DEVELOPMENT REVIEW BOARD--SPEED MEMO

**DRB CASE NO/PROJECT NO: 1001948**

## DEVELOPMENT REVIEW BOARD TRANSPORTATION DEVELOPMENT Standard Comment Sheet

DESCRIPTION OF REQUEST: COMBINE TWO TRACTS INTO ONE. SKETCH PLAT REVIEW & COMMENT

SKETCH PLAT			
TRACT CA1, EAST CENTRAL MULTI-SERVICE CENTER AND LOT 6, BLOCK 3, BEVENS ADDITION			
BERNALILLO COUNTY NM		PROJECT NO. 02012DRB	
DATE:	5-13-2002	DRAWN BY:	KW, MS
REVISION DATES:		CHECKED BY:	CS
		SHEET 1 OF 1

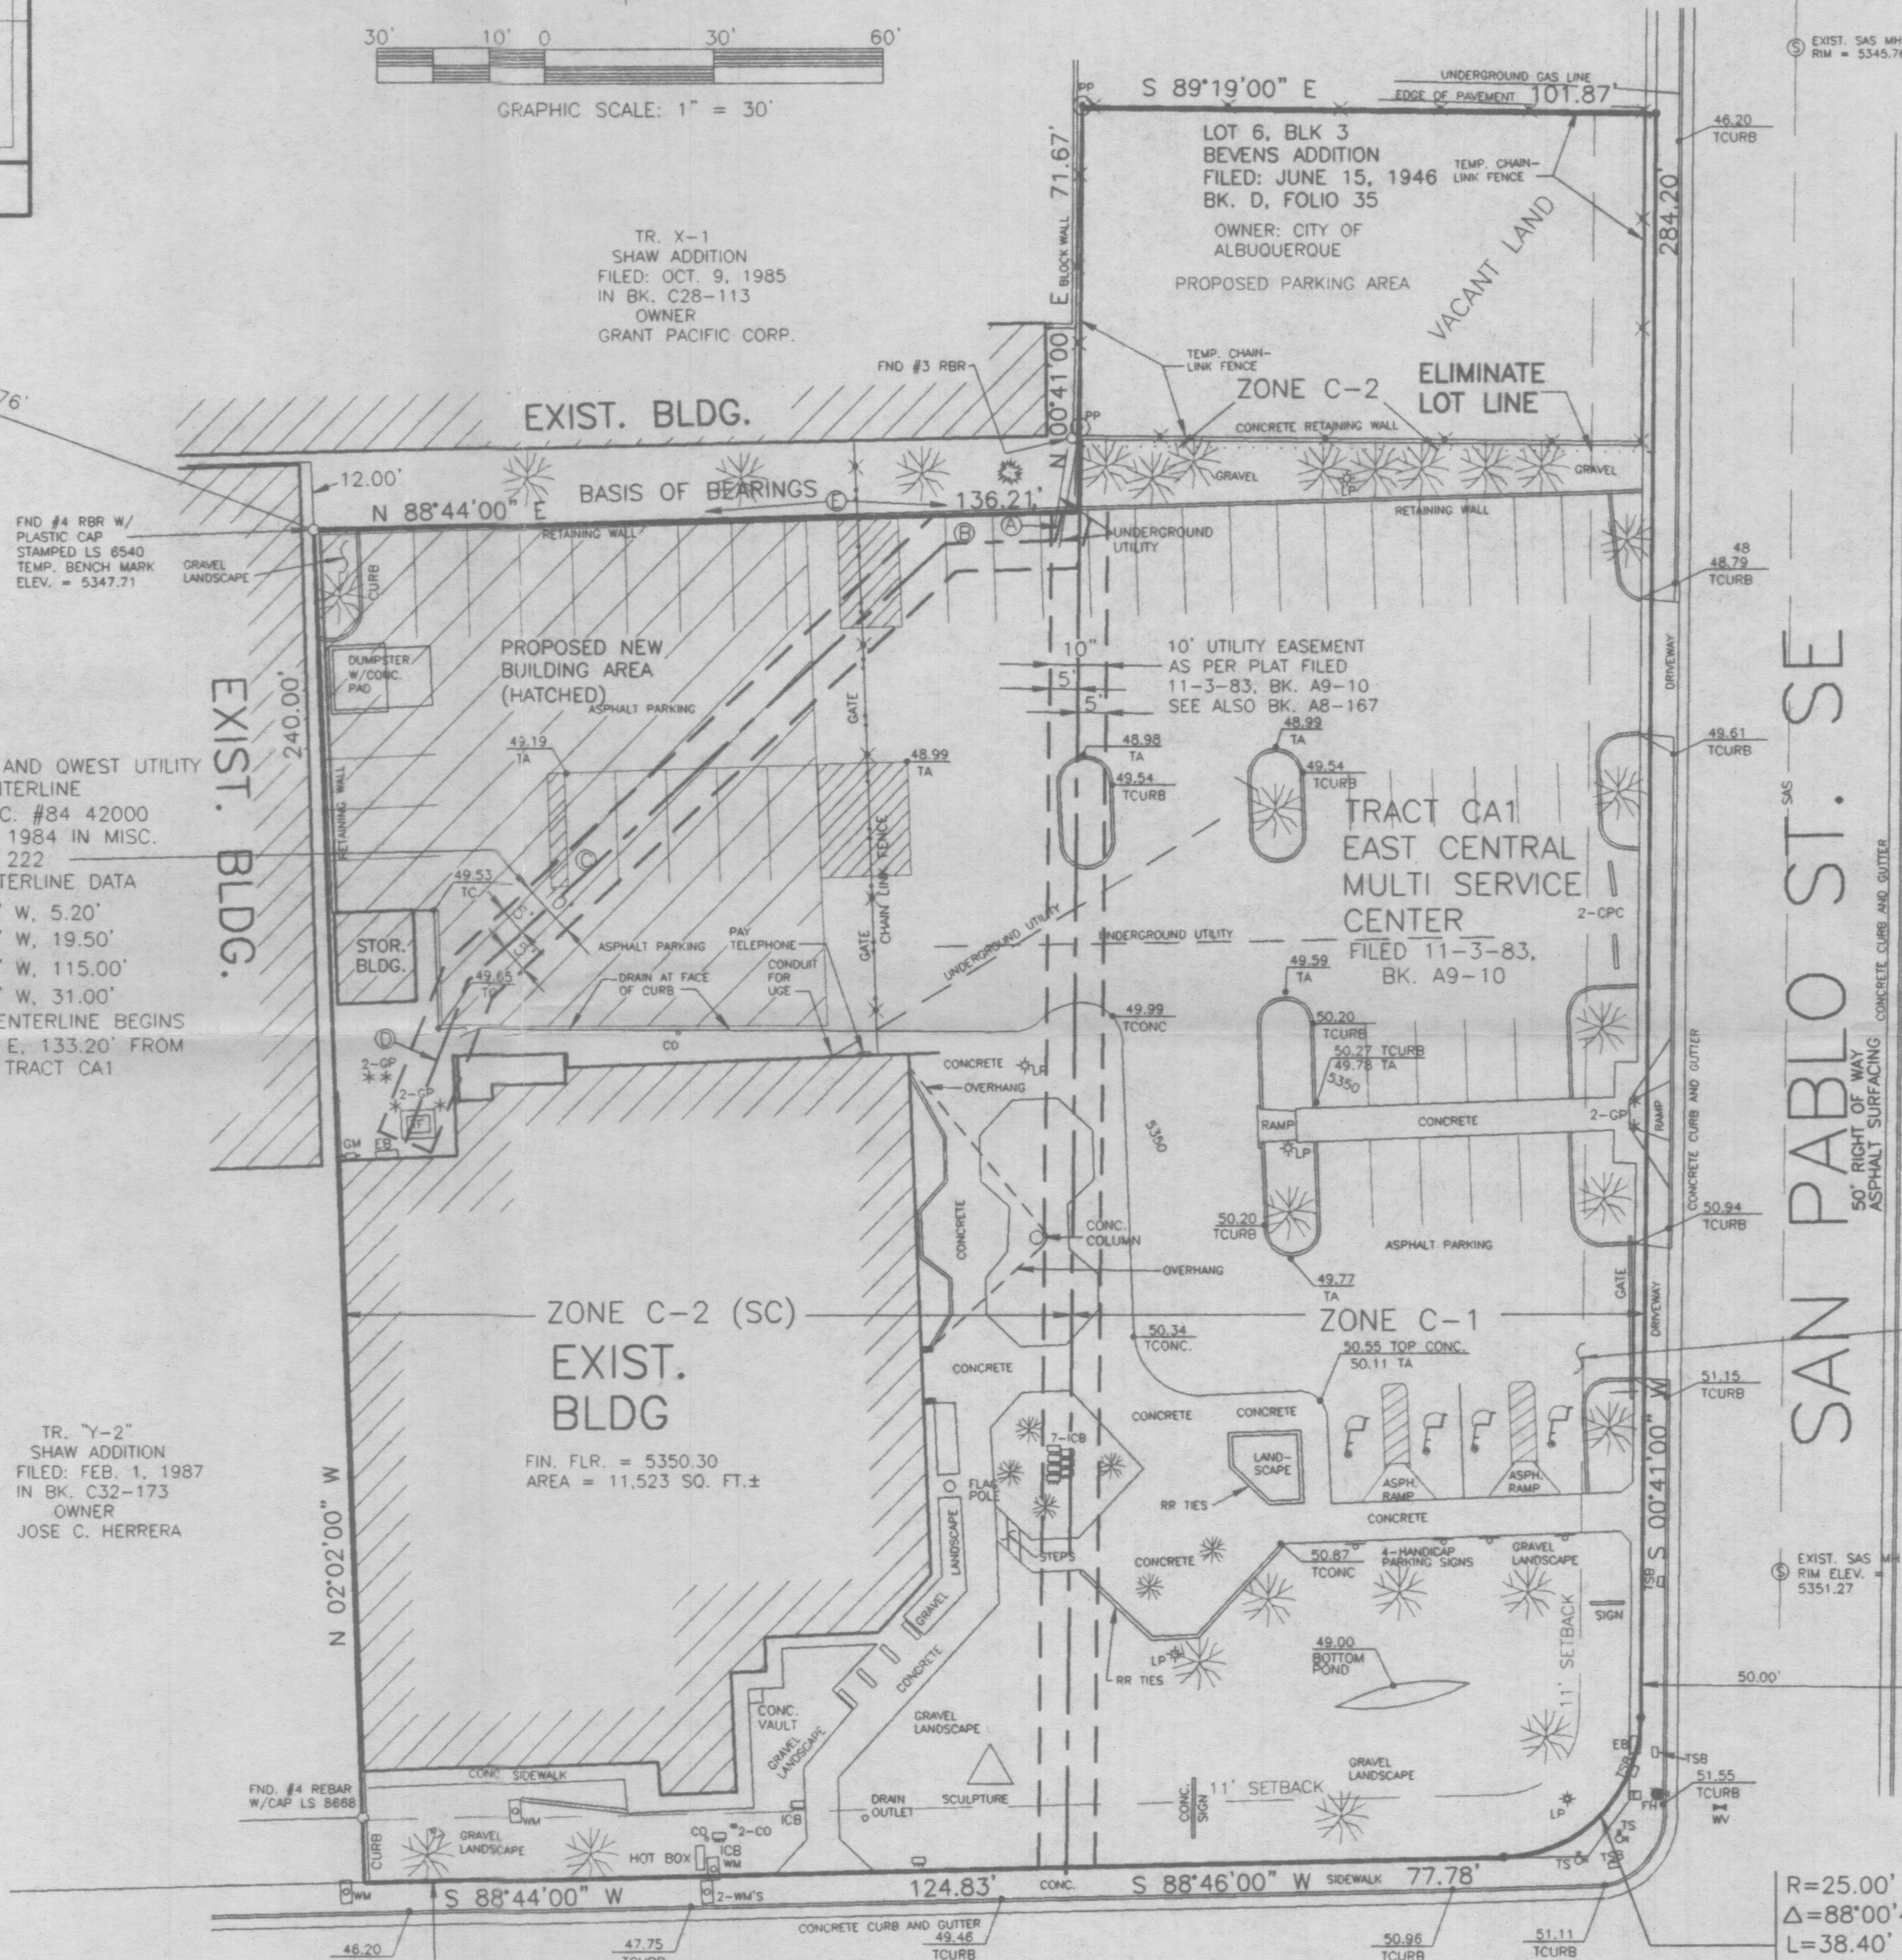
- Dedication of right-of-way to provided 9 feet from the face of curb to the property line is needed for San Pablo.
- Dedication of right-of-way to provided 10 feet from the face of curb to the property line is needed for Zuni.
